**OXFORDSHIRE COUNTY COUNCIL’S RESPONSE TO CONSULTATION
ON THE FOLLOWING DEVELOPMENT PROPOSAL**

Application no: 21/03268/OUT

Location: NW Of Baynards House, Ardley

Response Date: 13th December 2022

JOB TITLE LAND AT M40 JUNCTION 10		CLIENT ALBION LAND	
DRAWING TITLE WESTERN SITE ACCESS GENERAL ARRANGMENT			
SCALE 1:500@A1	DRAWN BY RM	DATE 03/08/21	DRAWING No 17213-09-GA
			REVISION P0

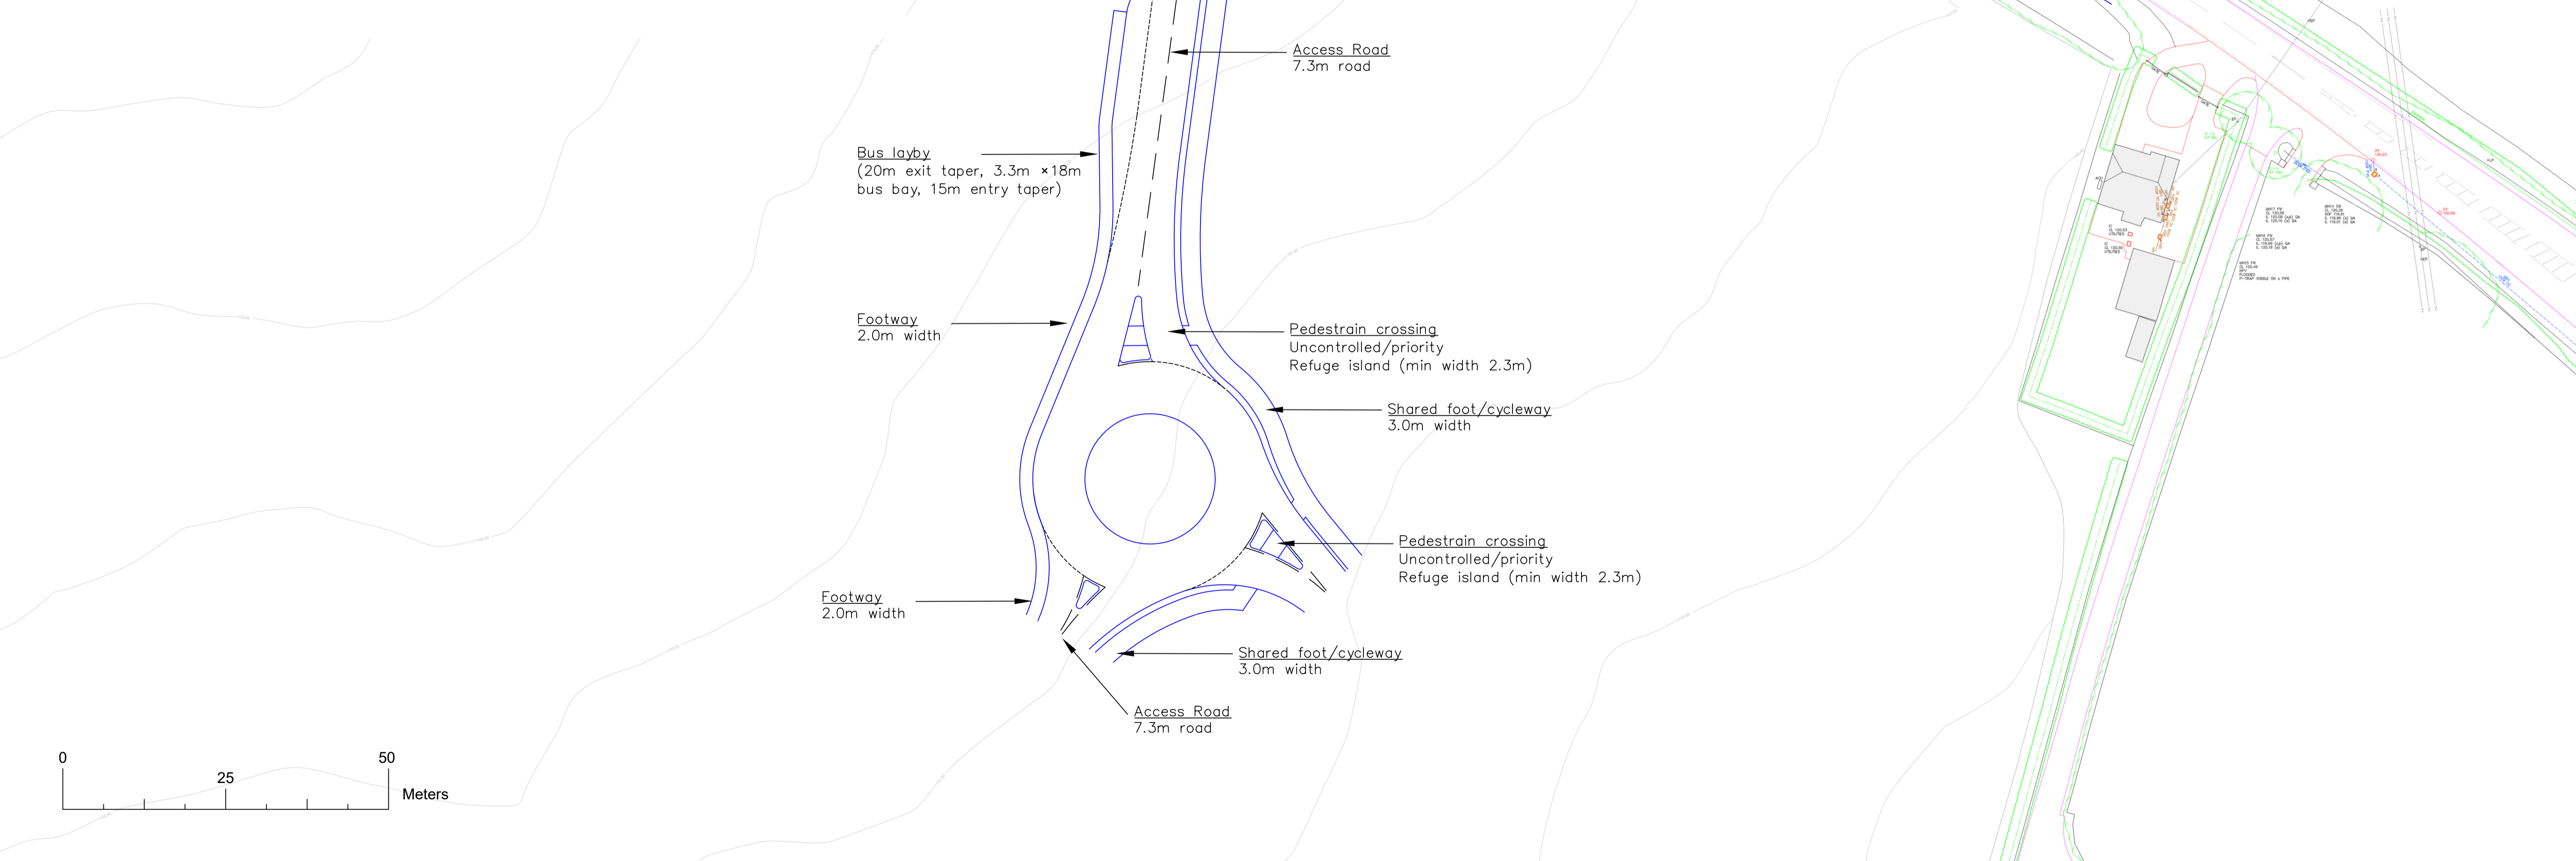
- The footway/cycleway appears to go outside the highway boundary on the B4100 western arm:

- This will need to be addressed in the design, as the footway cycleway link is necessary to make the development acceptable and to provide safe access to the western site.
- Where land allows, the footway/cycleway should have a greater separation from the carriageway.
- The scheme would require land within the site to be dedicated as highway.
- A drawing should be provided showing the proposed scheme alongside the development access roundabout, so that we can see the interrelationship between the two.
- It isn't clear whether the developer would intend to deliver the scheme under a S278 agreement – this should be clarified.
- I am concerned that the split into three lands on the northbound approach to the roundabout looks quite short, especially given the position of the crossing.
